From: Laura Gibbons <laura.gibbons@arun.gov.uk>
Sent: 07 December 2021 08:15
To: Simon Davis <Simon.Davis@arun.gov.uk>
Subject: RE: FW: Planning Consultation on: A/212/21/DOC

From: Laura Gibbons <Laura.Gibbons@arun.gov.uk>
Sent: 30 November 2021 15:30
To: Simon Davis <Simon.Davis@arun.gov.uk>
Subject: RE: FW: Planning Consultation on: A/212/21/DOC

Formpave Diffuser tank construction

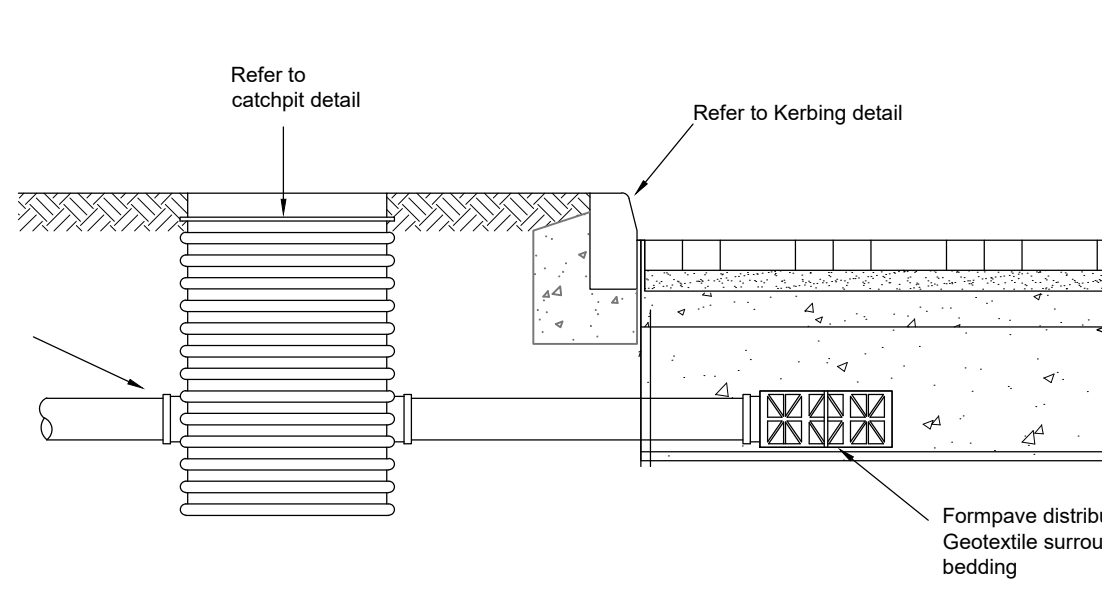
I've given the latest proposals another review. Due to an explanation provided I no longer require diffusers to be located above 1 in 10 year plus CC event. However, there is an error on the layout, which shows a diffuser unit 1m below the formation level. Which is no good.
